From: Boryn, Agnes <agnes.boryn@westyorkshire.police.uk>
Sent: 29 September 2025 14:55
To: Liz Chippendale; DC Admin
Subject: DOCO comments for application 2025/92438 at land off Fitzwilliam Street, Huddersfield

Re: 2025/92438- Temporary use of vacant land as TRU staff car park and associated works (within a Conservation Area) at land off Fitzwilliam Street, Huddersfield

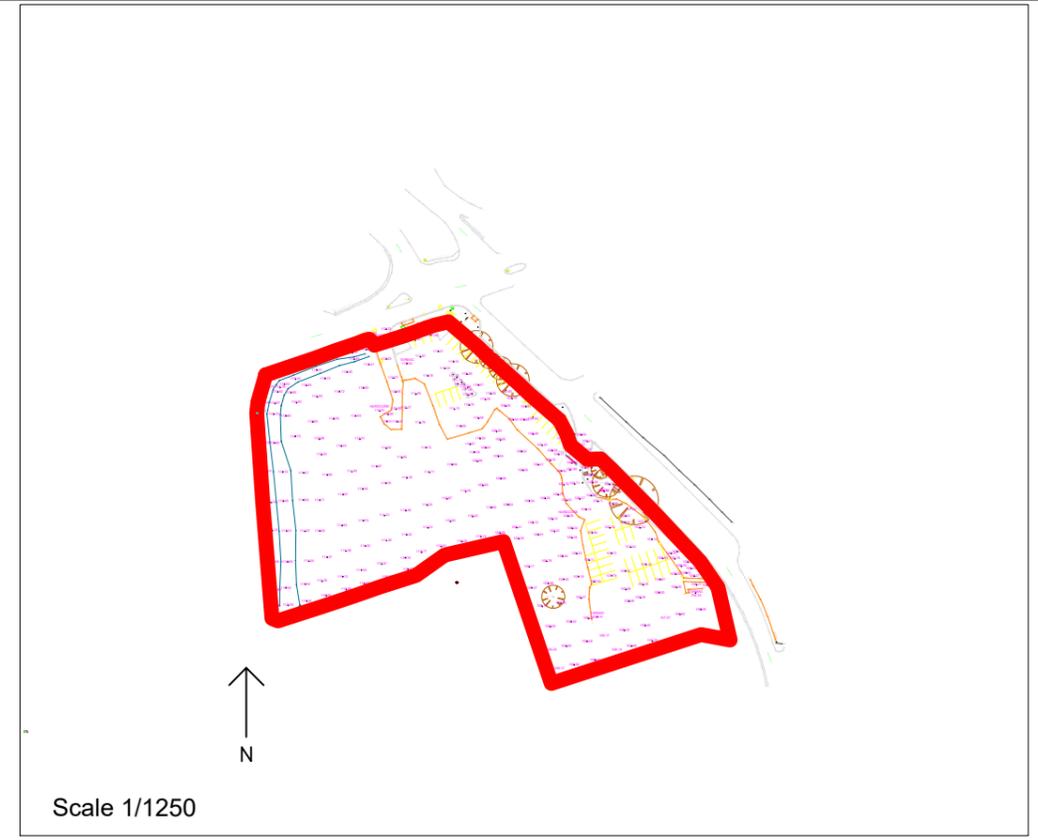
Submitted plans indicate that the gates will match the design of the adjacent new V-mesh fencing. This is supported from a crime reduction perspective. The gates should close any gap beneath them to ground level.

Due to the mention of using the site for storing materials, equipment and tools, I would recommend that the V-mesh fencing is rated to LPS 1175 Issue 8 Security Rating C5 (formerly known as SR3) as a minimum. Gates should be certified to the same standard. The use of dark coloured coatings on metal fencing systems reduces light reflection, thereby making it easier for passers-by to observe activity through the fencing.

Care should be taken to remove climbing aids from the vicinity of the new fencing and existing hoarding to impede scaling of both.
